From: Simon Davis
Sent: 06 December 2018 09:20
To: [REDACTED]
Subject: FW: P/107/18/DOC 7 Webb Close

From: Laura Gibbons
Sent: 06 December 2018 09:18
To: Simon Davis
Subject: RE: P/107/18/DOC 7 Webb Close

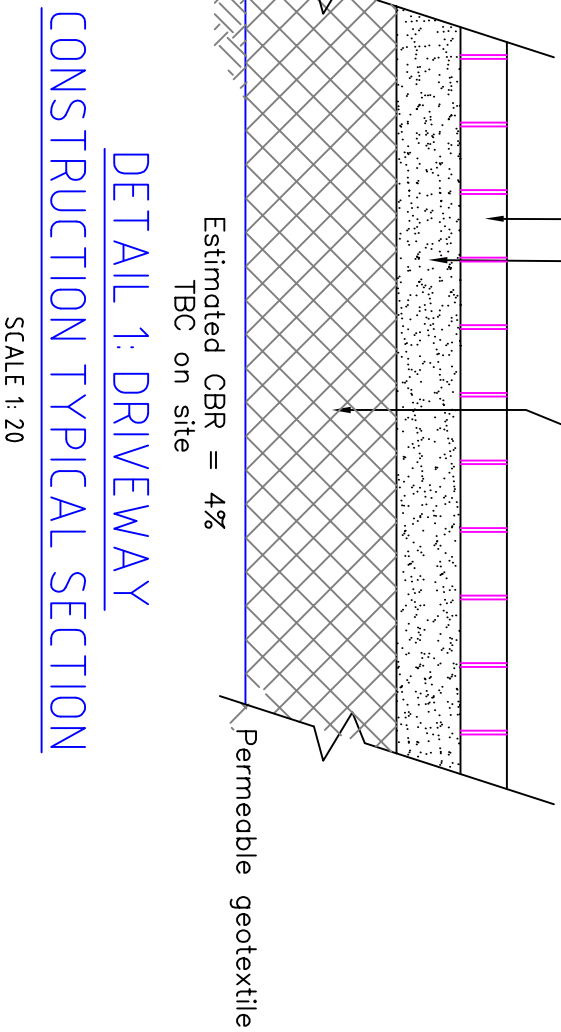
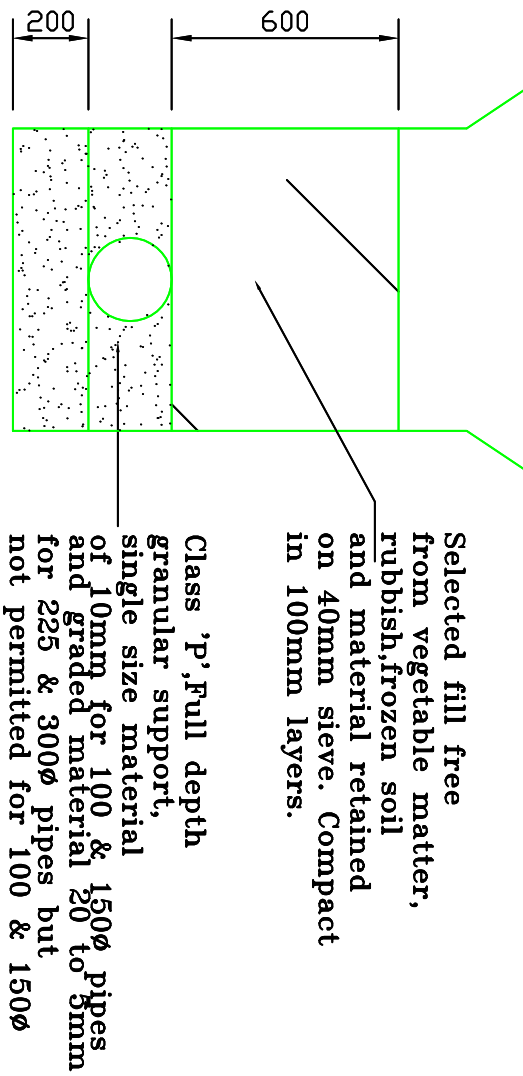
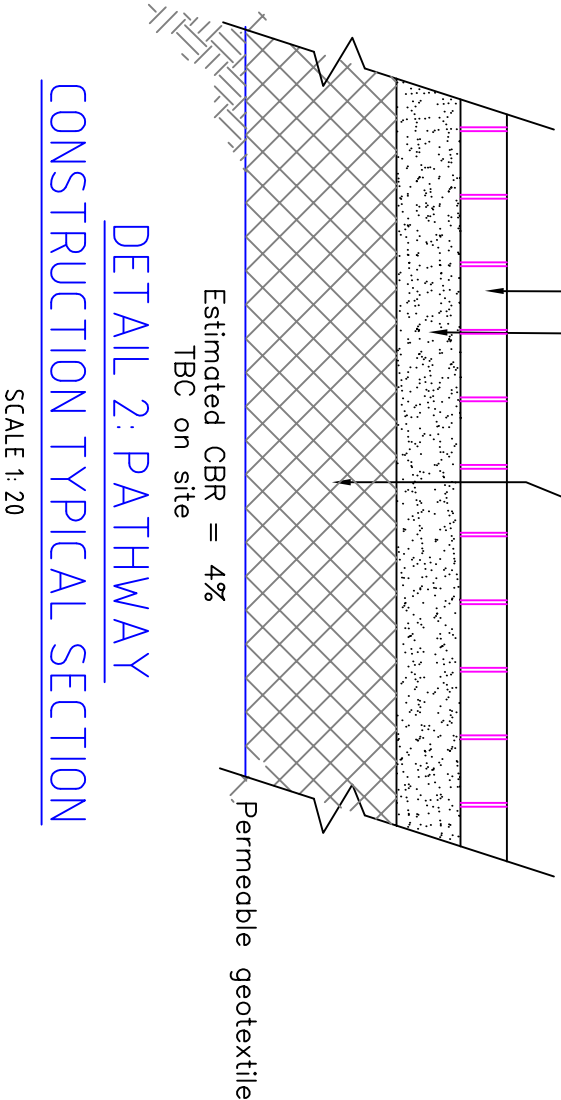
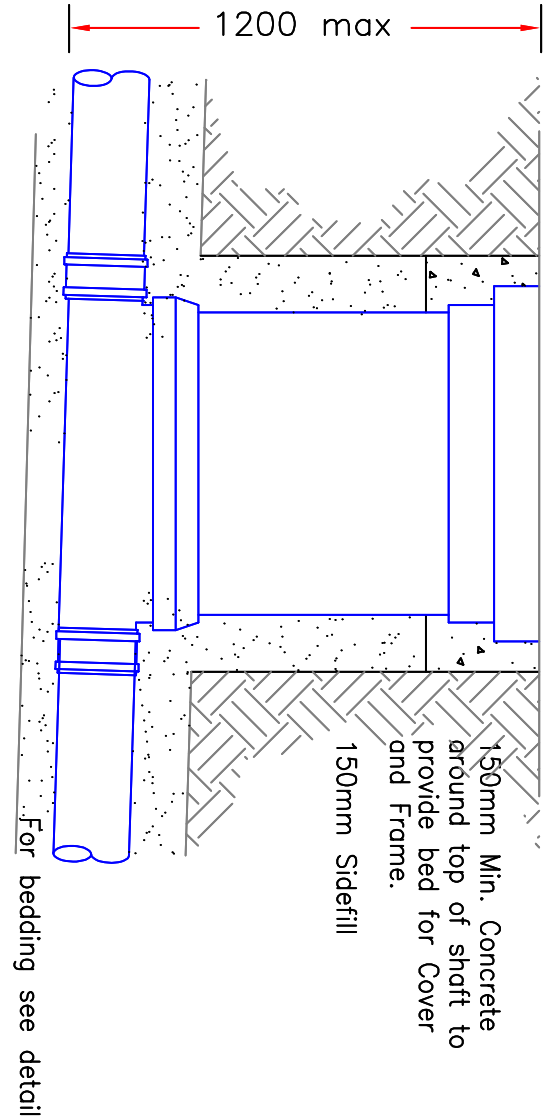
The soakaway details are fine. Can the permeable paving and driveway details be updated to include a permeable geotextile fully wrapping around the sub base, not just under it. And the pipe details for pipes 900-1200mm deep under roads and bedding for other flexible pipes need to both be updated to include a minimum of 150mm granular bed and surround (including the top). I apologise that I did not pick up on this before.
